CROSSROADS MIXED USE FILING NO. 2

CONSTRUCTION PLANS

TITLE SHEET

STREET IMPROVEMENT PLANS

**CENTRAL RAIL POINT &
EX SOUTHERN RAIL POINT**

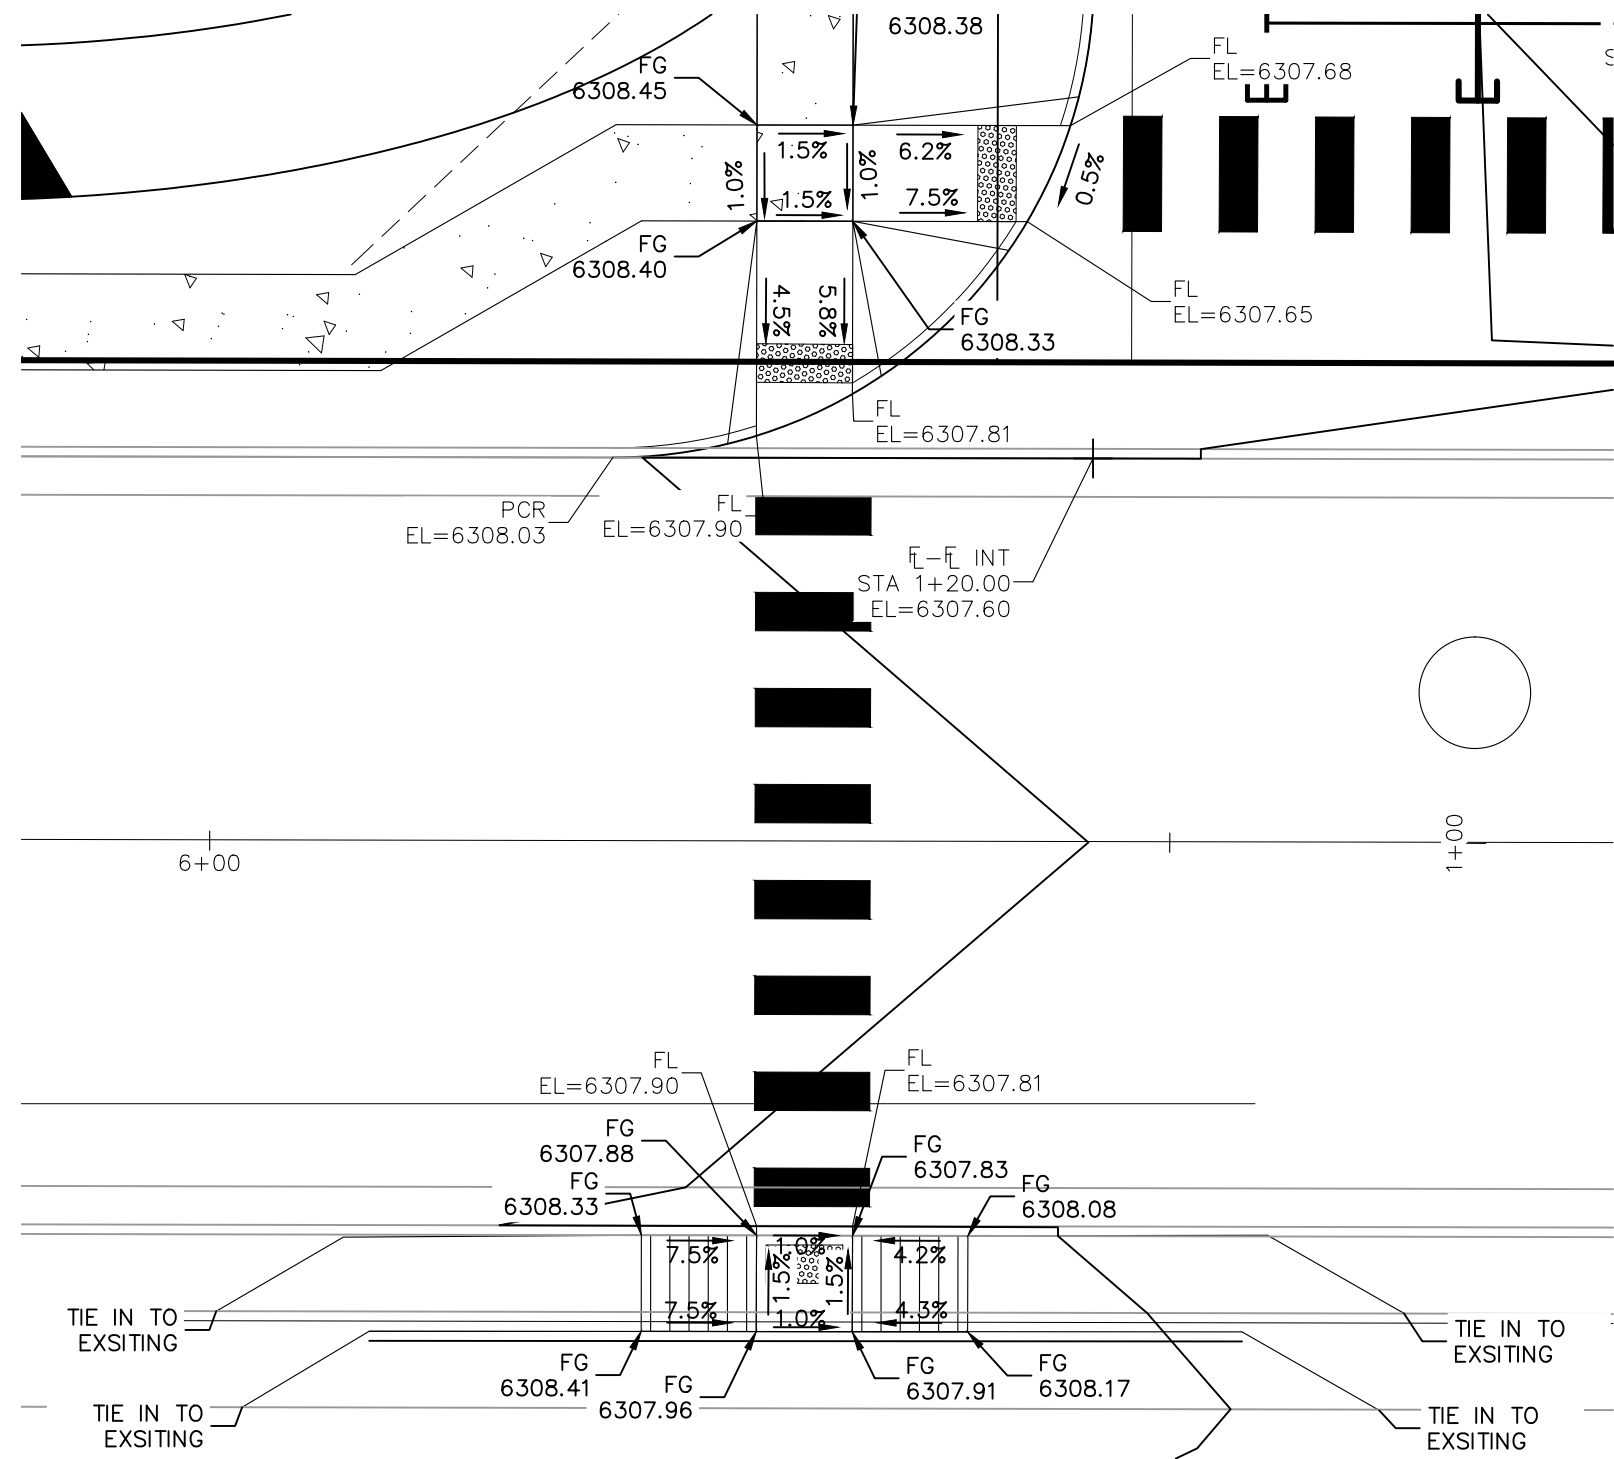
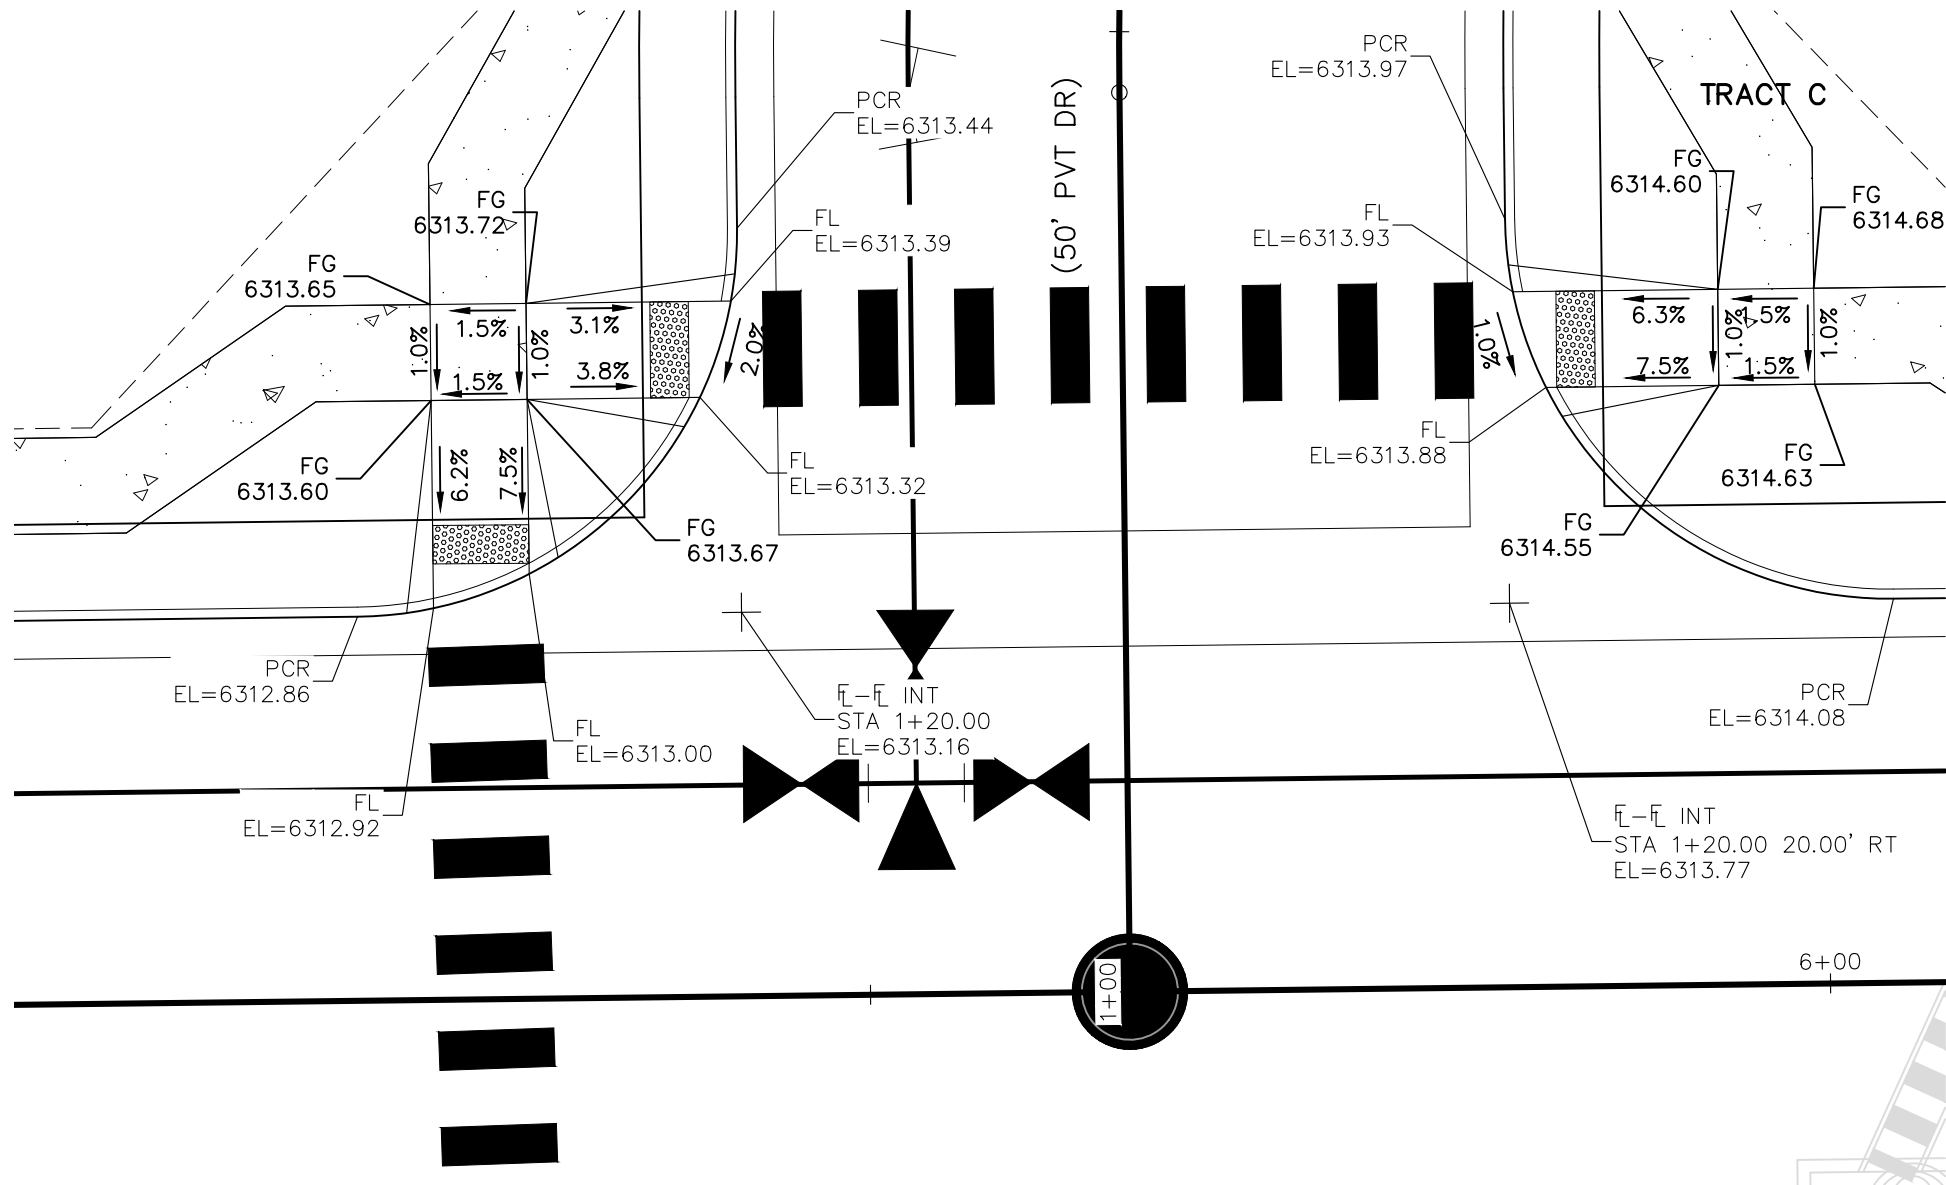
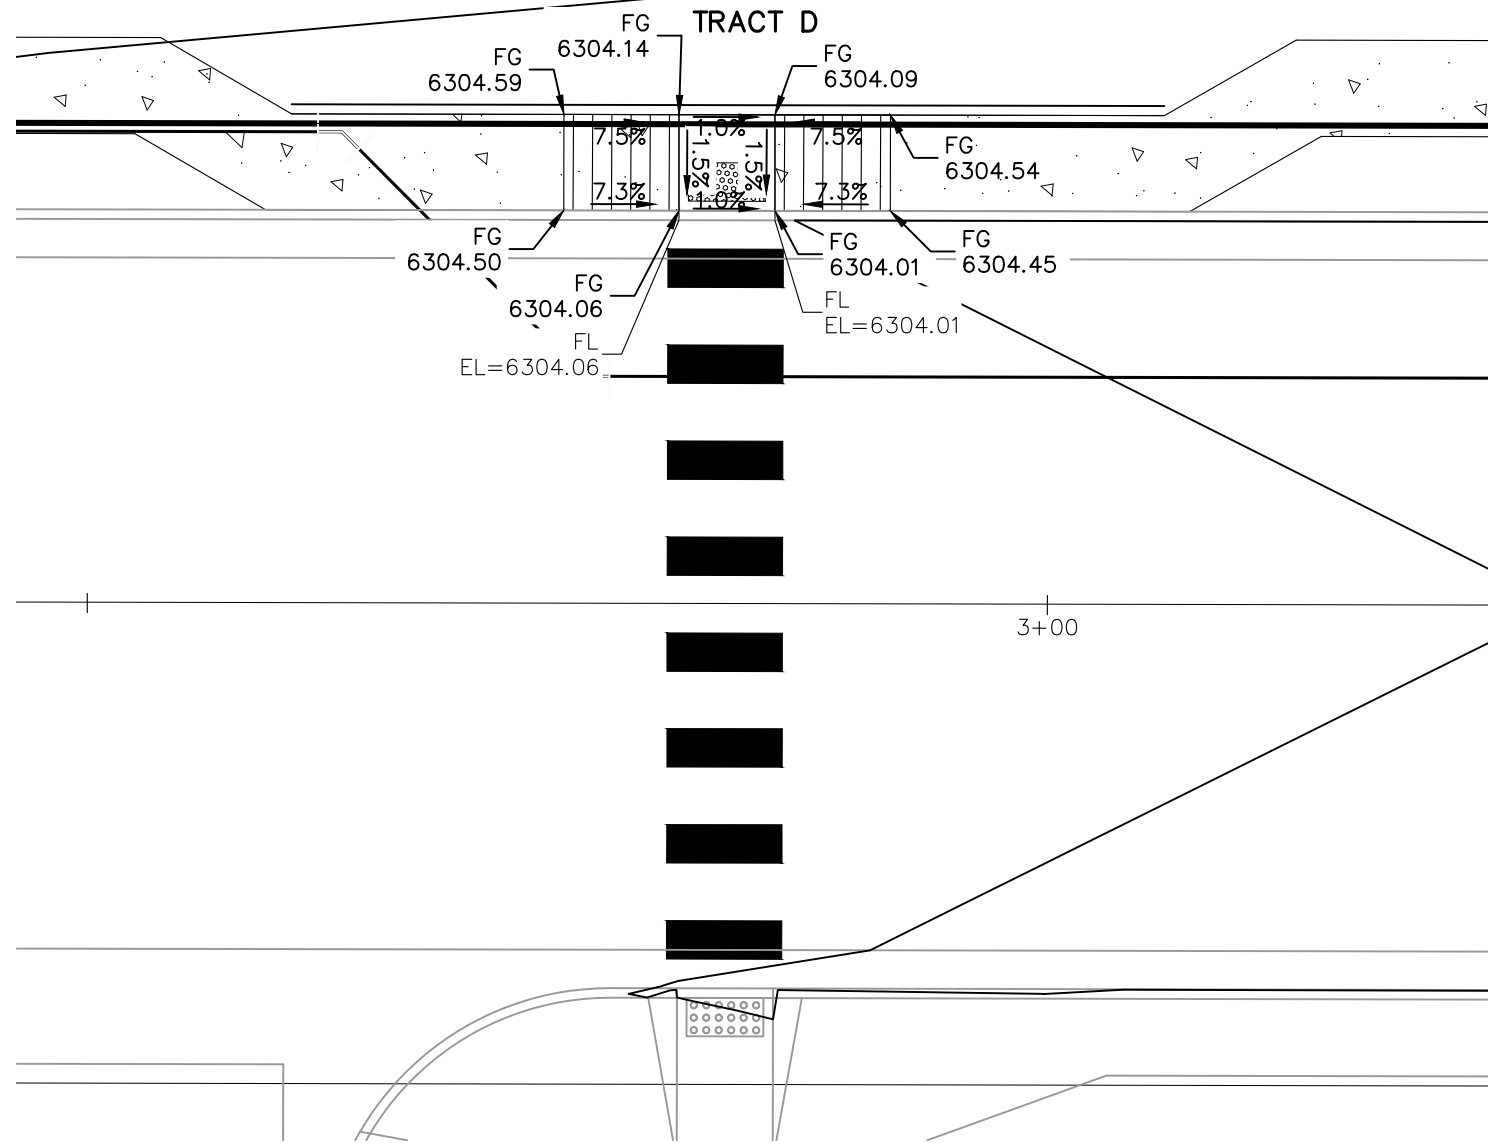
Per Aura at Crossroads see snippet. Revise to provide a sidewalk/crosswalk across proposed curb ramp per ECM 2.5.2.C.3 and 2.5.2.C.4.

Show/Install sidewalk along the east side of Southern Rail Point

update all proposed sidewalk alignment at the intersections per the county standard detail.

The snippet shown below would be a crosswalk to the future construction development of Lot 1, not to the central rail way corner.

The sidewalk will be updated for future development when the lots are developed for this filing No.2 in order to avoid the need for demolition once the Tract B site is developed.

The Note is pointing to the parcel lot lines which have now been labeled in S103. The sidewalk will be updated for future development when Tracts B and C are developed for this filing, in order to avoid the need for demolition once the Tract B and C sites are developed.
